Application No: AL/46/26/S73

Recommendation Report for Application under Section 73 for the Removal or Variation of Conditions
Under a Previously Approved Permission

LOCATION: Plot 3 (not yet constructed)
Fontwell Avenue
Eastergate
PO20 3RU

PROPOSAL: Variation of condition following the grant of AL/114/24/S73 relating to approved plans, vehicular access and pedestrian crossing and visibility splays.

Drawing Status		Planning	
Client			
Anna-Marie Ferrier			
Project			
Land West of Fontwell Avenue, Fontwell			
Drawing Title			
Access Overview & Visibility Splays			
Scale	Date	Drawn by	Checked by
As Shown	July 26	EMH	SMO
Drawing No.			Rev.
2026-6677-1002			A

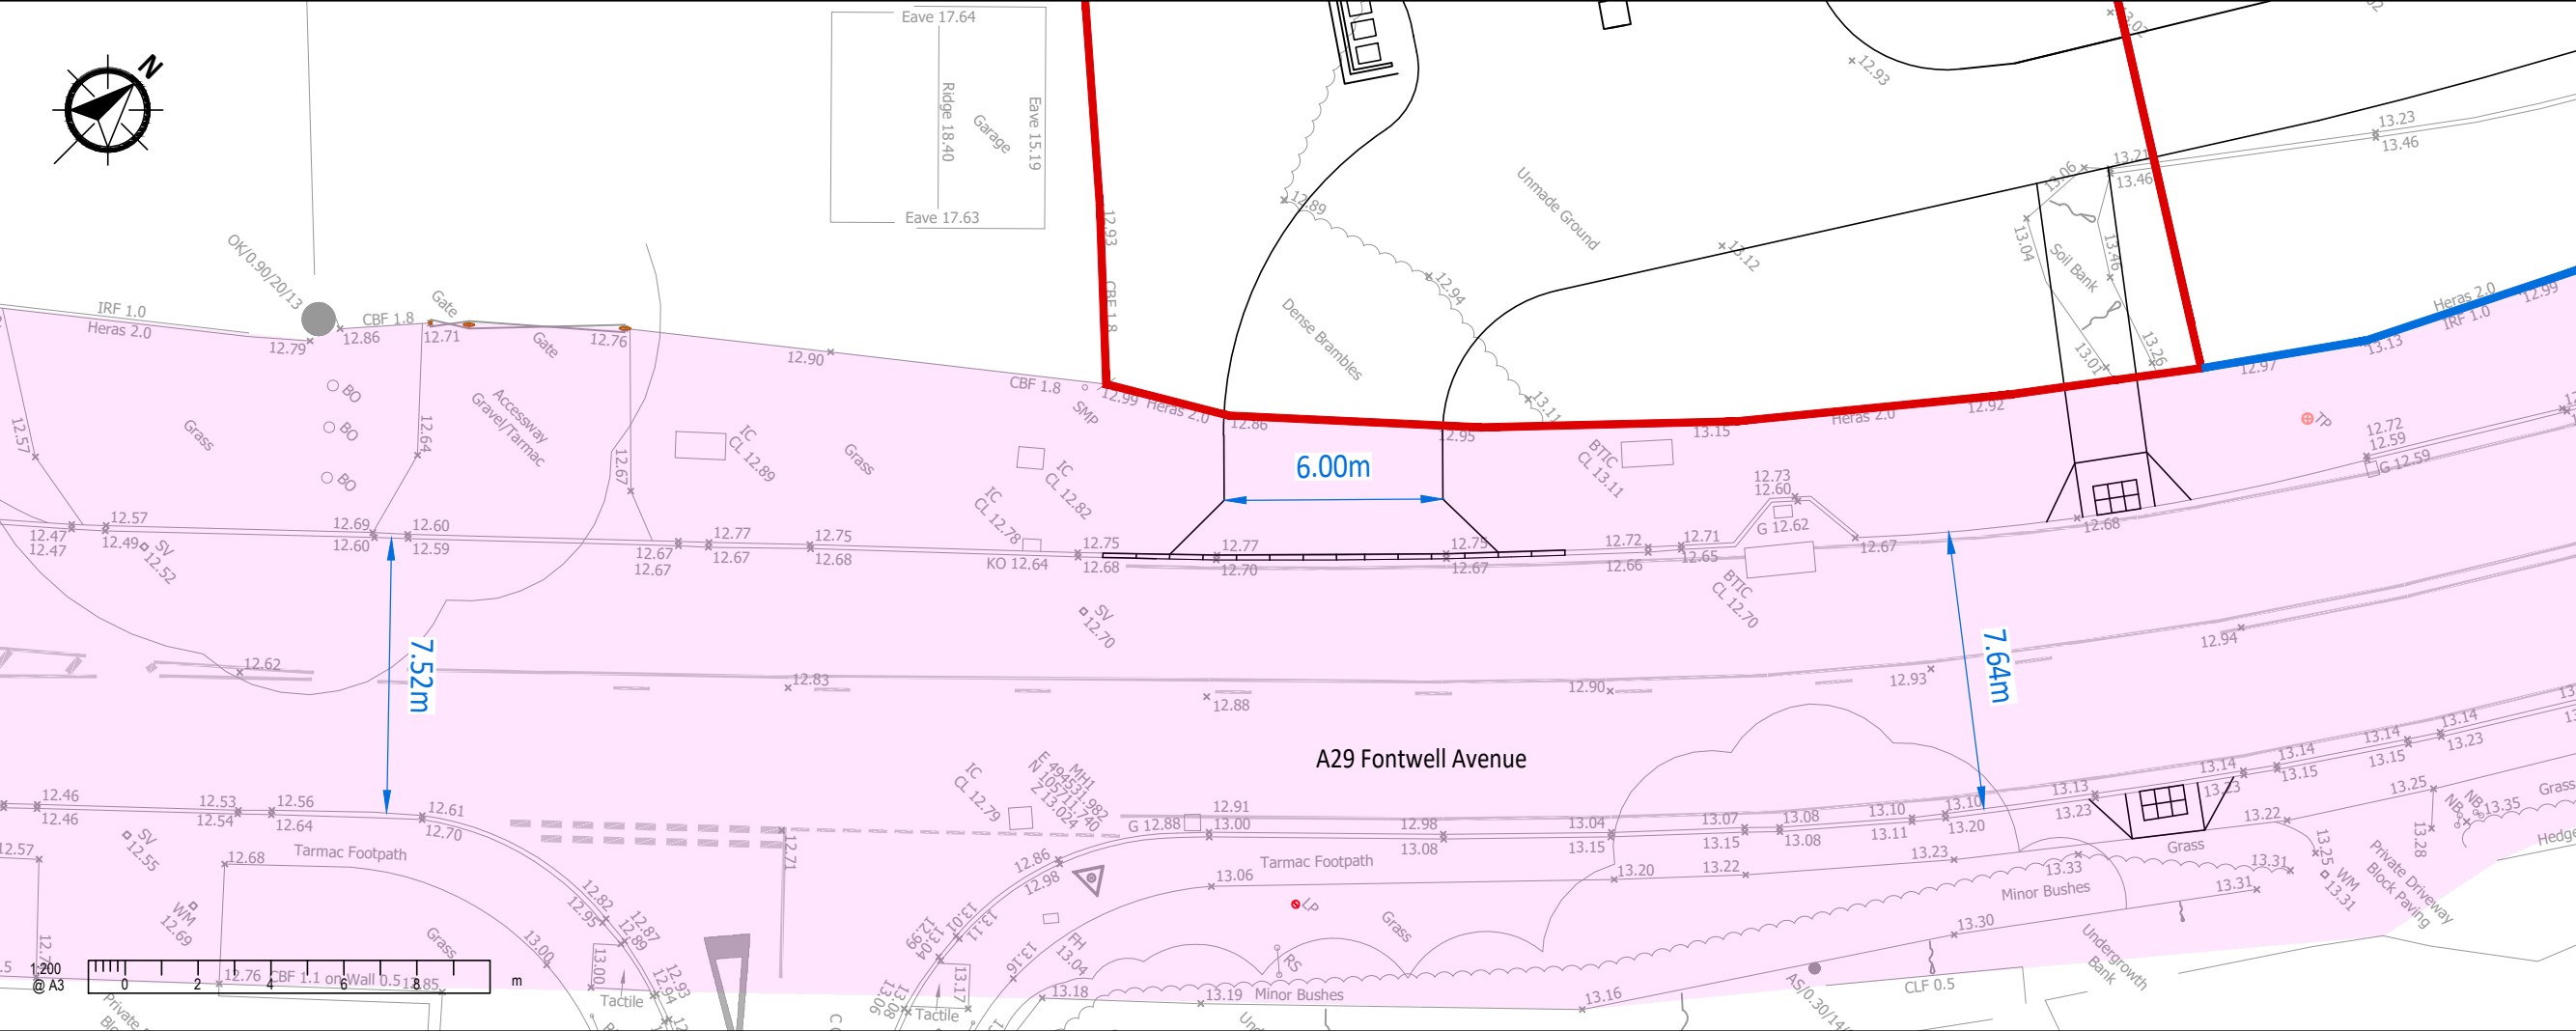
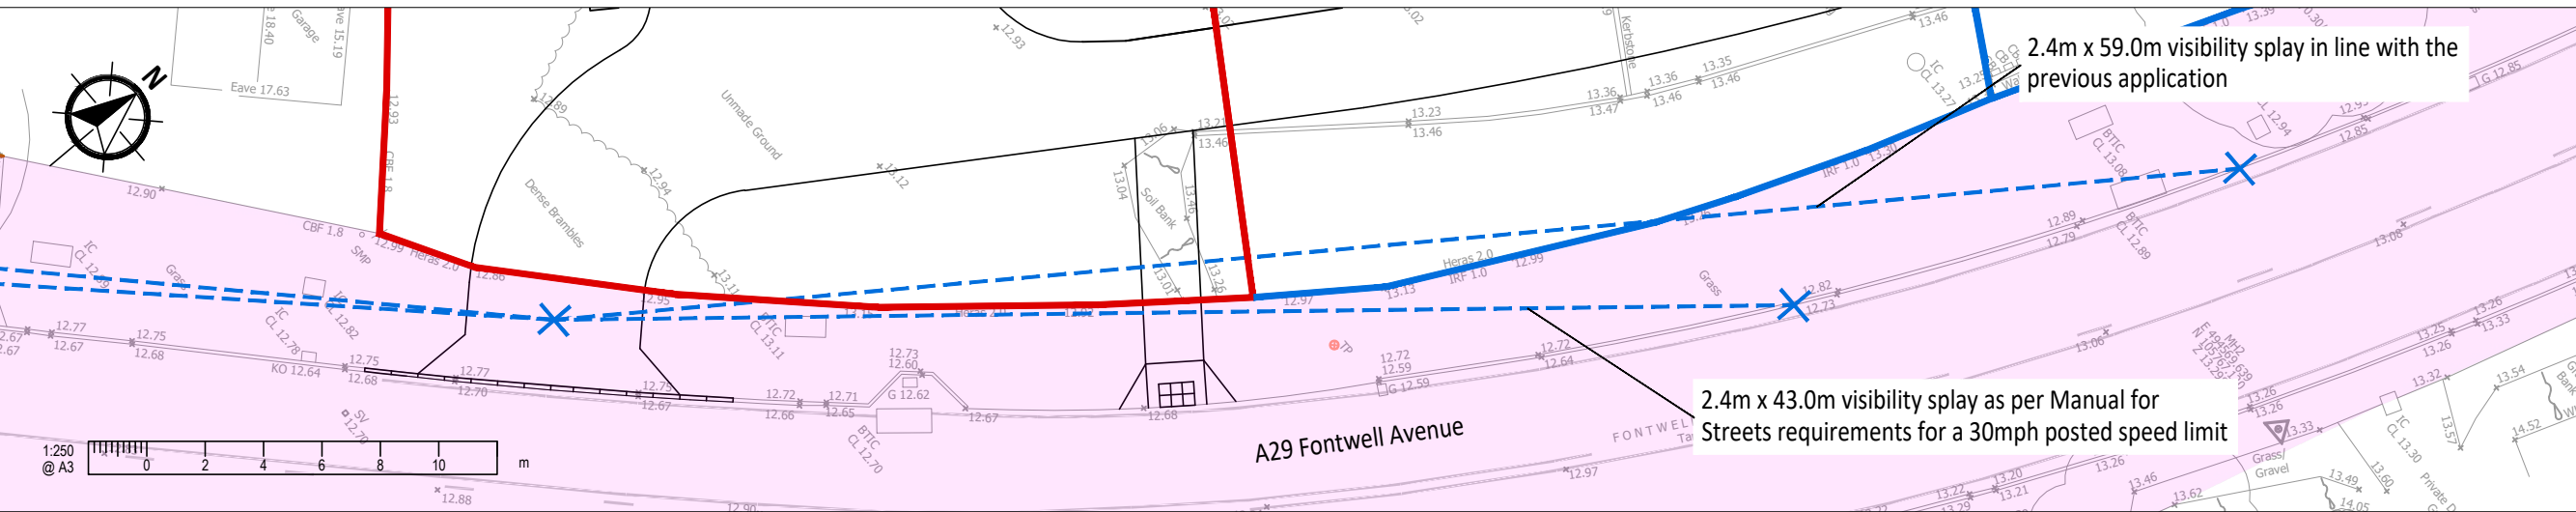
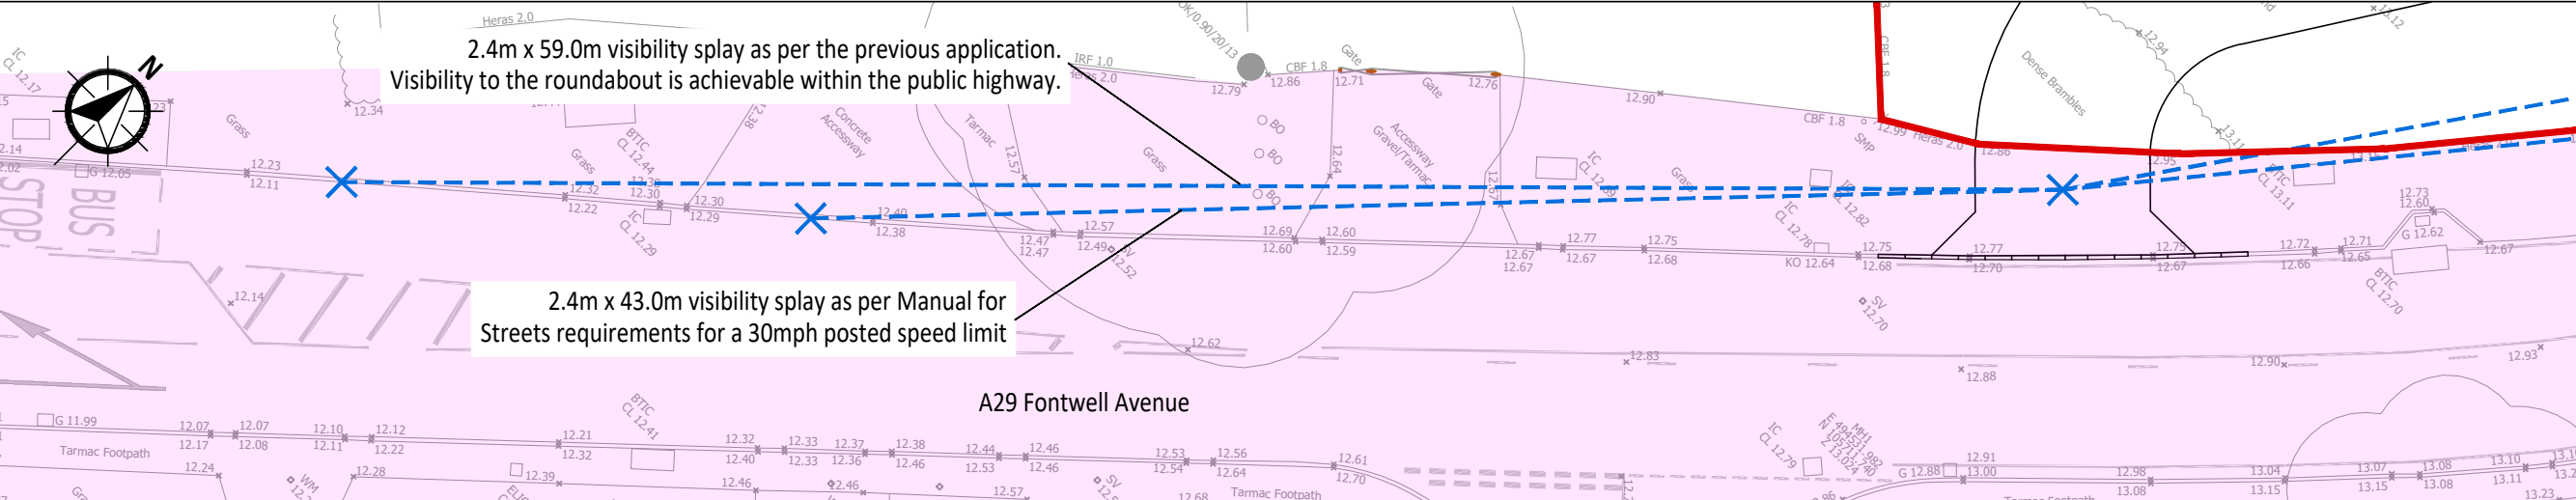
WSCC Highways - More information requested. Vehicular visibility splays of 2.4m x 43m in accordance with 30mph speed limit have been demonstrated from the amended access location. In previous applications visibility splays of 59m had been provided and the Highways Statements states that splays in excess of 43m can be achieved. Require clarification of the previous 59m splay. Whilst it is acknowledged that the posted limit is now 30mph, it would be useful for maximum achievable splays (within publicly maintained highway and applicant land) to be provided whilst being mindful of any impact a greater splay may have on landscaping on site frontage.

Comments noted. Visibility splays were provided and WSCC have been reconsulted. Comments awaited.

WSCC Highways requested an additional visibility splay. This has been provided and further comment is awaited. On the basis that the splays are achievable and no objections were raised previously, it is not considered the alterations would result in harm in respect to road safety or capacity.
